Application number: 2025/92713	
What is the application for?:	Reserved matters application pursuant to outline permission 2023/92079 for erect
Address of the site or building:	Rear of, 23 to 43, Moor Lane, Gomersal, Cleckheaton, BD19 4LF
Postcode:	LS10 1NB

Type of comment: An objection	
Do you wish your comments to be published on the website anonymously?	Yes
<p>Latest Amended Plans Moor Lane Gomersal Ref 2025/ 9273</p> <p>Impact on Summerdale</p> <p>I refer to the following Drawing No Reference 2539 -D - 20 - 006 - Proposed site sections, prepared by AJH Architects on behalf of PPJ Developments, which shows the relationship of Plot 10 to No 21 Summerdale.</p> <p>It also shows the gradual fall of the land and the relative heights of the houses from the top to the bottom of the site.</p> <p>All of the houses follow the general land gradient until plot 10 is reached.</p> <p>It can be clearly seen that plot 10 ridge is actually higher than the adjacent plot 9 of the development by approximately 500mm.</p> <p>This being due to Plot 10 being a 5 Bed 7 person house, which is the 2nd largest on the development.</p> <p>Aesthetically it looks wrong, but more importantly this extra height a

2539 - D - 20 - 016

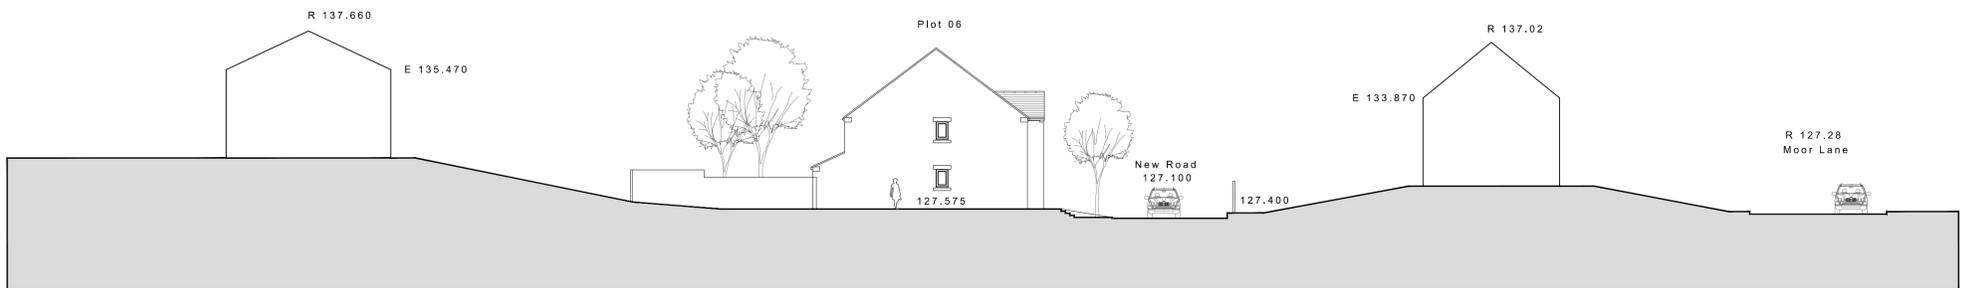
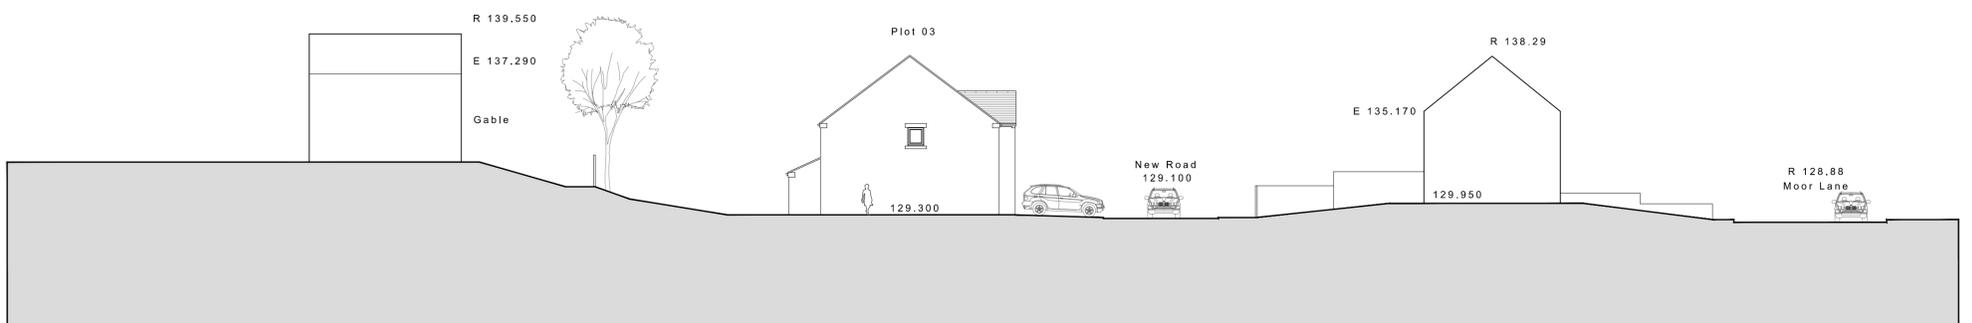
As we still have a cramped and intensive proposal and nothing has changed, so how can the development be now approved.
